SSD 10477 – Stage 3 Facilities Sydney Business Park, Marsden Park

ATTACHMENT A

Review of the engineering plans by Orion Consulting for stage 3 Sydney Business park, Project No. 20-0127, Set 02, Rev. A, Dwg. No. 000 to 602, dated 31.07.20 raised the following issues:

ISSUED FOR **DEVELOPMENT APPLICATION**
NOT FOR CONSTRUCTION

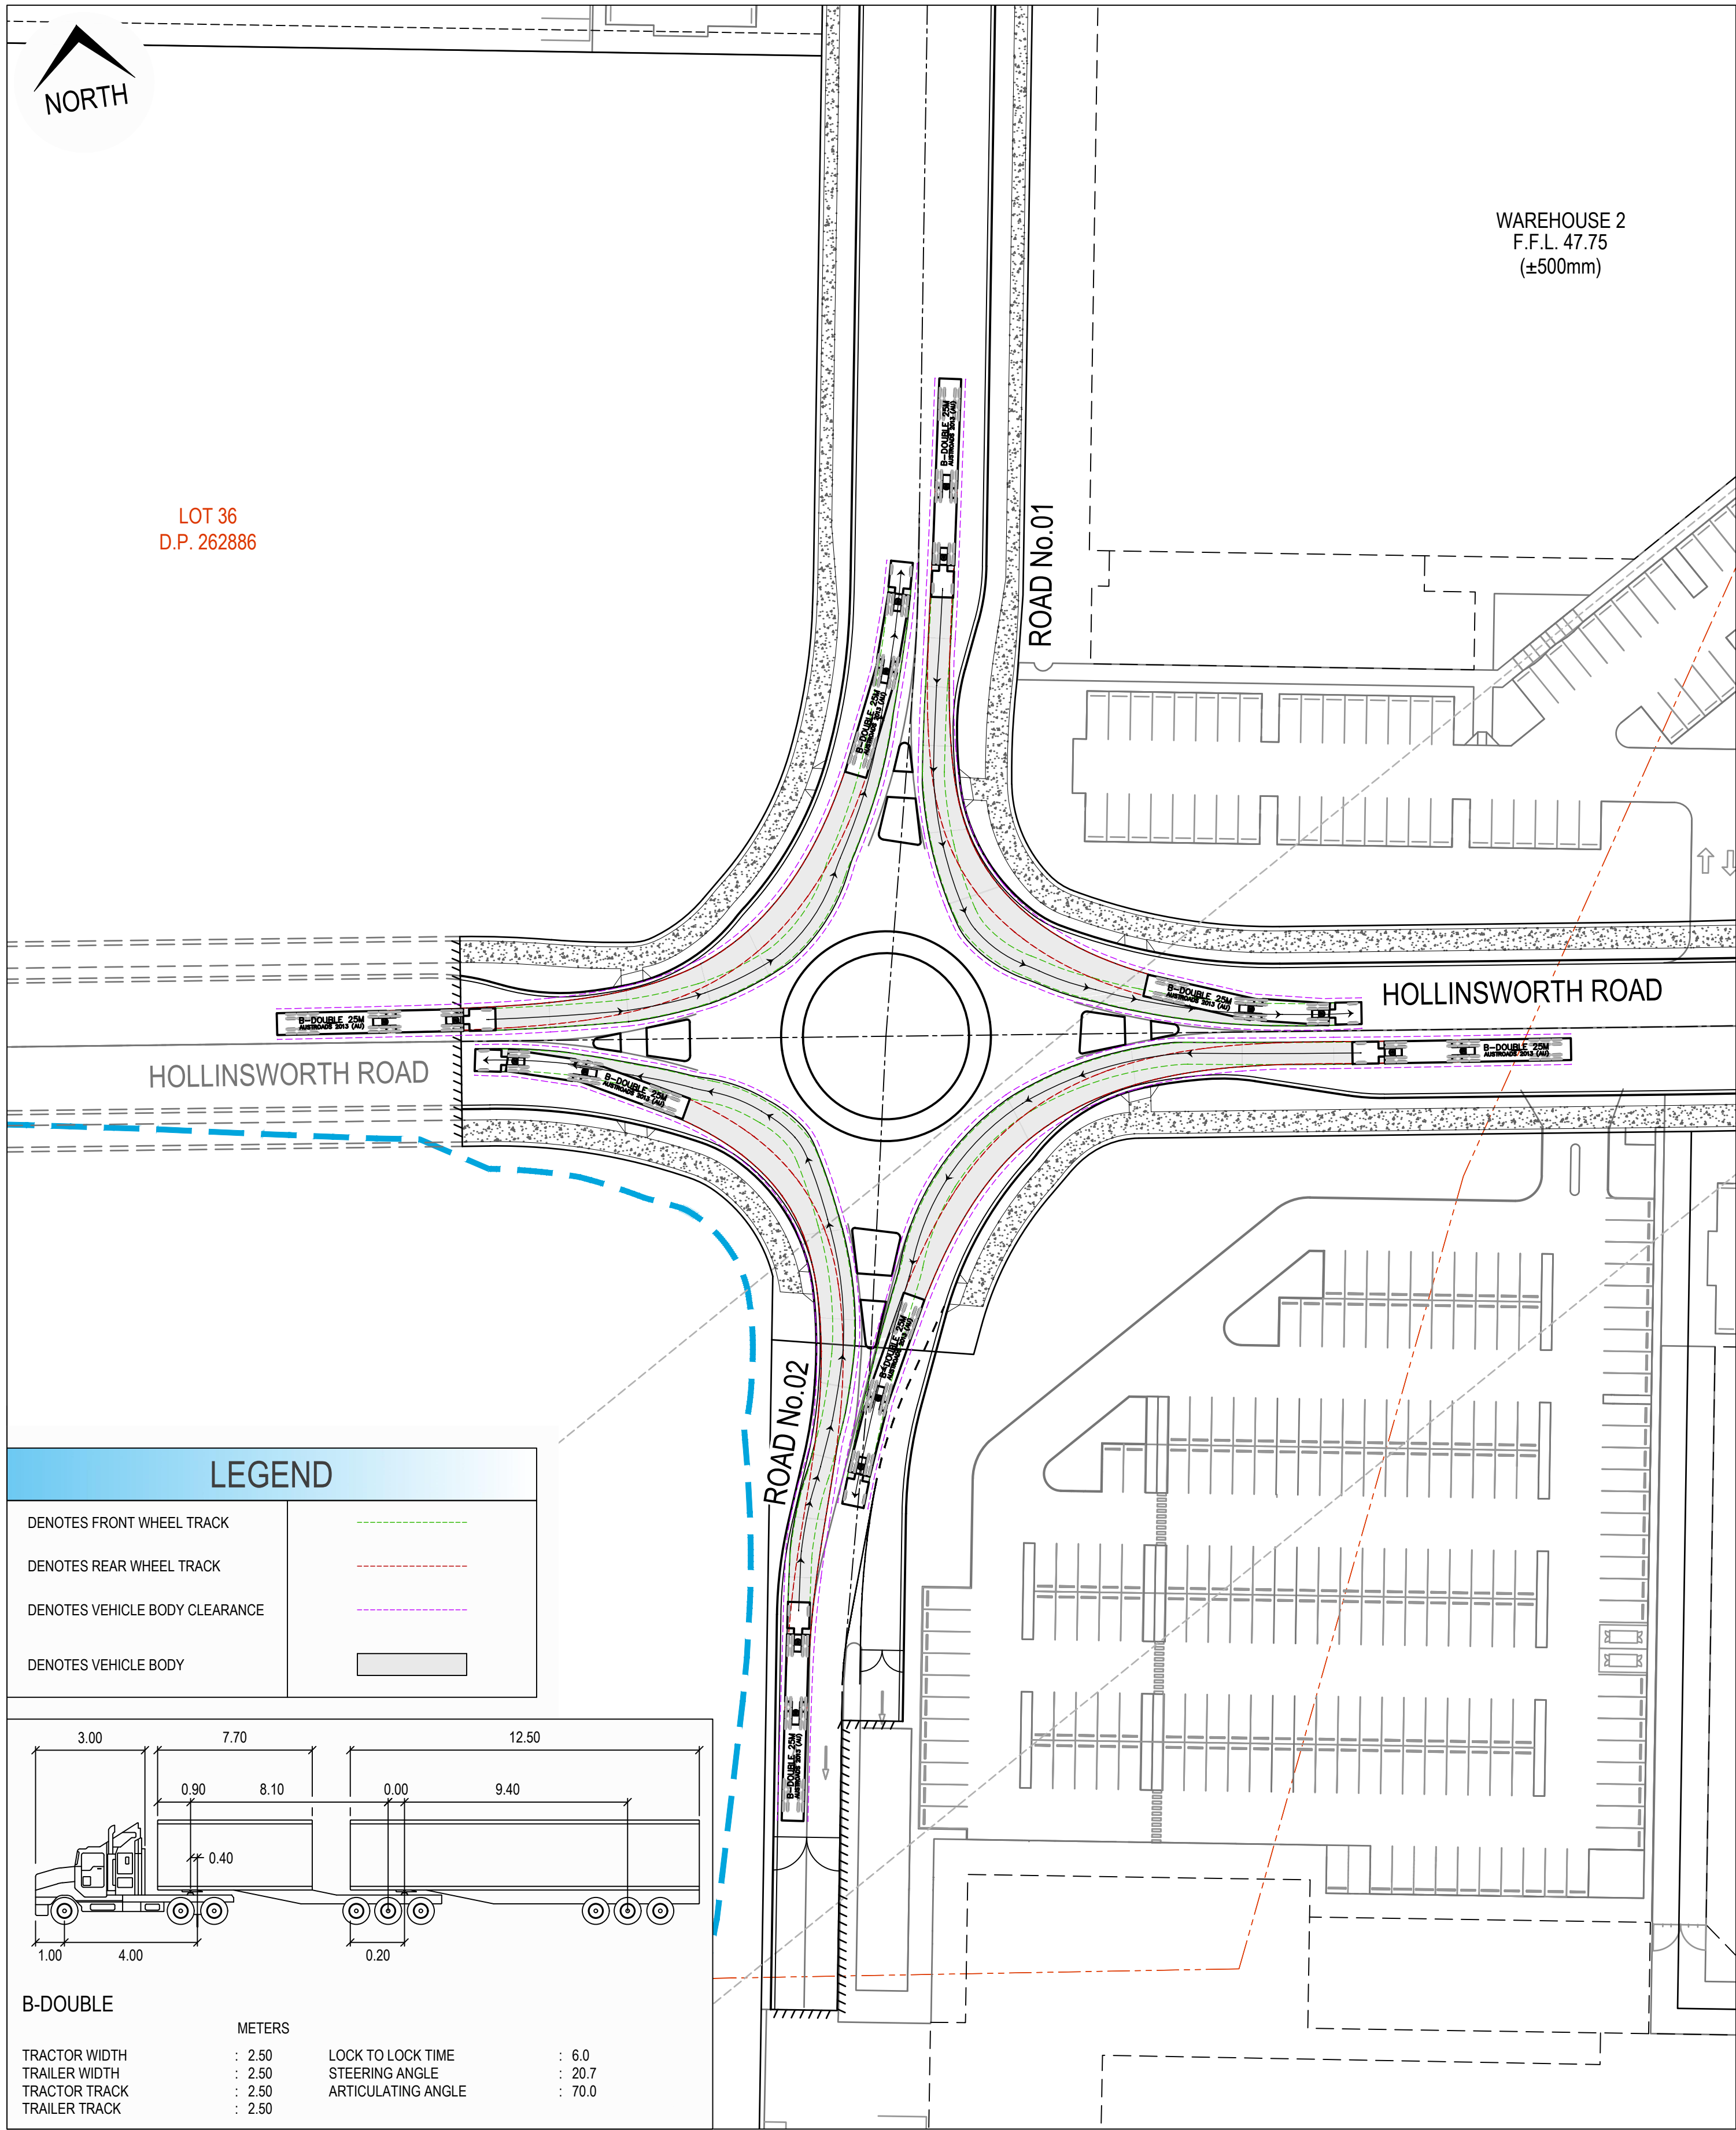
11. The design vehicle for the roundabout is a B-triple, for which turning / swept paths will need to be provided on a copy of the engineering plans. Council's Traffic team is to identify if the turning paths presented are compliant.
